18 August 2022

### **Murwillumbah High School Bushfire Review - Comments**

Blackash has provided design advice and a Bushfire Hazard Assessment report for Murwillumbah High School State Significant Development (SSD-16848913) Educational Establishment at 86 Riverview Street, Murwillumbah which is legally known as Lot, 2//DP578679, Lot 5//DP820602 and Lot, 6//DP820602 (the site). This response has been provided by Lew Short (CV at Attachment 1) who is a Bushfire Planning & Design (BPAD) Level 3 Certified Practitioner (No. BPD-PA 16373).

Figure 7 Landscape Management Plan

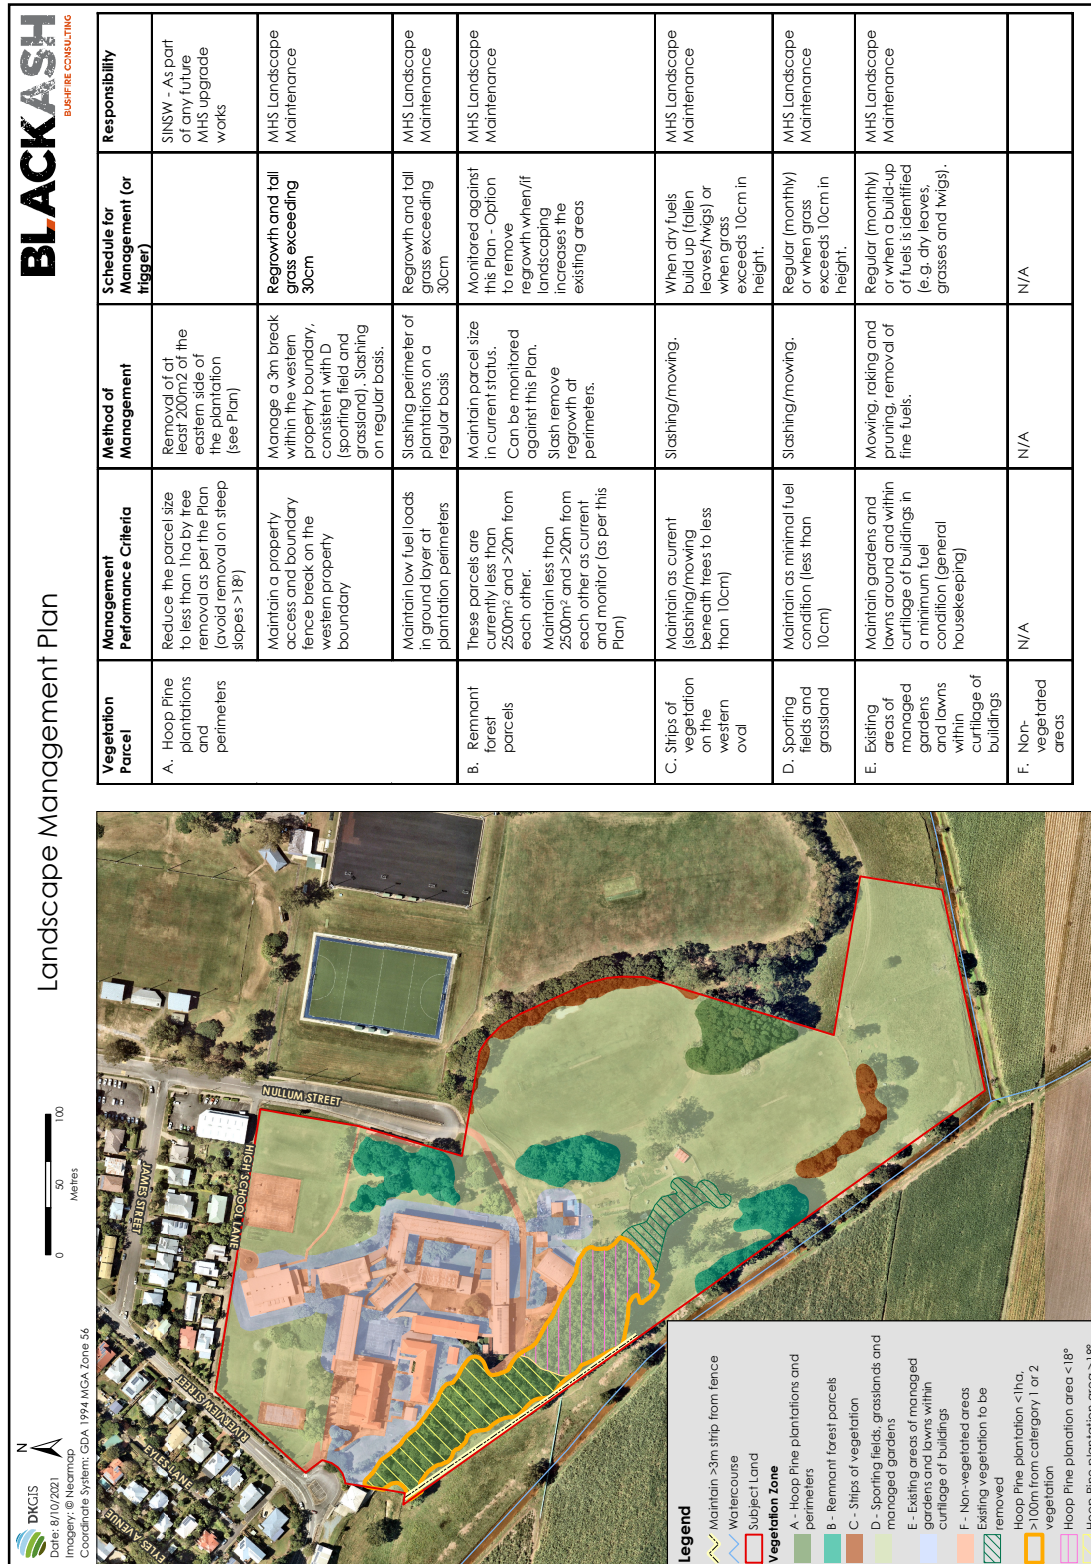
|          | 2. Bushfire                                                                                                                                                                                                                                                                                                                   |                                                                                                                                                                                                                                                                                                                                                                                                                                                                                                                                                                                                                                                                                                                                                                                                                                                                                                                                                                                                                                                                                                                                                                                                                                                                                                                                                                                                                                                                                                                                                                                                                                                                                                                                                                                                                                                                                                                                                                         |
|----------|-------------------------------------------------------------------------------------------------------------------------------------------------------------------------------------------------------------------------------------------------------------------------------------------------------------------------------|-------------------------------------------------------------------------------------------------------------------------------------------------------------------------------------------------------------------------------------------------------------------------------------------------------------------------------------------------------------------------------------------------------------------------------------------------------------------------------------------------------------------------------------------------------------------------------------------------------------------------------------------------------------------------------------------------------------------------------------------------------------------------------------------------------------------------------------------------------------------------------------------------------------------------------------------------------------------------------------------------------------------------------------------------------------------------------------------------------------------------------------------------------------------------------------------------------------------------------------------------------------------------------------------------------------------------------------------------------------------------------------------------------------------------------------------------------------------------------------------------------------------------------------------------------------------------------------------------------------------------------------------------------------------------------------------------------------------------------------------------------------------------------------------------------------------------------------------------------------------------------------------------------------------------------------------------------------------------|
| Blackash | <p>a. either amend the bushfire risk assessment to include further explanation and justification for identifying the hoop pine plantation as low threat vegetation or revise the bushfire risk assessment to include a bushfire APZ consistent with PBP 2019 between the proposed buildings and the hoop pine plantation.</p> | <p>The Bushfire Risk Assessment has been updated to reflect the management of the core and retained Hoop Pine areas to protect the <i>Rhodamnia rubescens</i> and Hoop Pine areas. An updated Bushfire Management Plan (formerly referred to as the Landscape Management Plan) has been completed that provides for retained vegetation areas of less than 1ha in the core Hoop Pine area and which retains the threatened species <i>Rhodamnia rubescens</i>.</p> <p>The core Hoop Pine area will be maintained to less than 1ha and as such meets the PBP 2019 test for low threat vegetation. The retained areas of Hoop Pine to the south of the core Hoop Pine area are separated from the core Hoop Pine area and are currently maintained by regular slashing. This will continue. As such, these areas meet the low threat vegetation test as required in PBP 2019. This will continue presenting a low hazard.</p> <p>The Bushfire Risk Assessment has been updated to reflect the management of the core and retained Hoop Pine areas to protect the <i>Rhodamnia rubescens</i> and Hoop Pine areas.</p> <p>PBP 2019 provides for low threat vegetation exclusions (section A1.10) stating (p. 88). The following is relevant to the consideration of the core Hoop Pine area and the maintained Hoop Pine areas:</p> <p>The following exclusions of AS 3959 apply, and are not required to be considered for the purposes of PBP, as detailed below:</p> <ol style="list-style-type: none"> <li>1. <i>Single areas of vegetation less than 1 hectare in area and greater than 100 metres separation from other areas of Category 1 or 2 vegetation.</i></li> <li>2. <i>Vegetation regarded as low threat due to factors such as flammability, moisture content or fuel load, including grassland managed in a minimal fuel condition, mangroves and other saline wetlands, maintained lawns, golf courses such as playing areas and fairways,</i></li> </ol> |

|  | c. revise the bushfire risk assessment to demonstrate how the hoop pine plantation would be managed to the standard of an Asset Protection Zone without impacting the habitat viability for the critically endangered flora species, Rhodamnia rubescens, occurring within the hoop pine plantation. | Bushfire Management Plan (formally referred to as the Landscape Management Plan) has been revised to provide for managed areas of the Hoop Pine and retention of threatened plants.                                                                                                                                                                                                                                                                                                                                                                                                                                                                                                                                    |

The Bushfire Risk Assessment has been updated to reflect the management of the core and retained Hoop Pine areas to protect the *Rhodamnia rubescens* and Hoop Pine areas. An updated Bushfire Management Plan (formally referred to in the EIS as the Landscape Management Plan) has been completed (see Appendix 2 of the updated Bushfire Risk Assessment), that provides for retained vegetation areas of less than 1ha in the core Hoop Pine area and which retains the threatened species *Rhodamnia rubescens*. The core Hoop Pine area will be maintained to less than 1ha and the sugar cane to the south of the site is a managed crop and as such meets the PBP 2019 test for low threat vegetation. The retained areas of Hoop Pine to the south of the core Hoop Pine area are separated from the core Hoop Pine area and are currently maintained by regular slashing. This will continue. As such, these areas meet the low threat vegetation test as required in PBP 2019. This will continue presenting a low bushfire hazard.

Following extensive work by a range of specialists, particularly the Biodiversity Development Assessment Report, modification is required to protect the *Rhodamnia rubescens* and Hoop Pine areas. An updated Bushfire Management Plan (formally referred to in the EIS as the Landscape Management Plan) has been completed (see Appendix 2 of the updated Bushfire Risk Assessment) that provides for retained vegetation areas of less than 1ha and which retains threatened species.
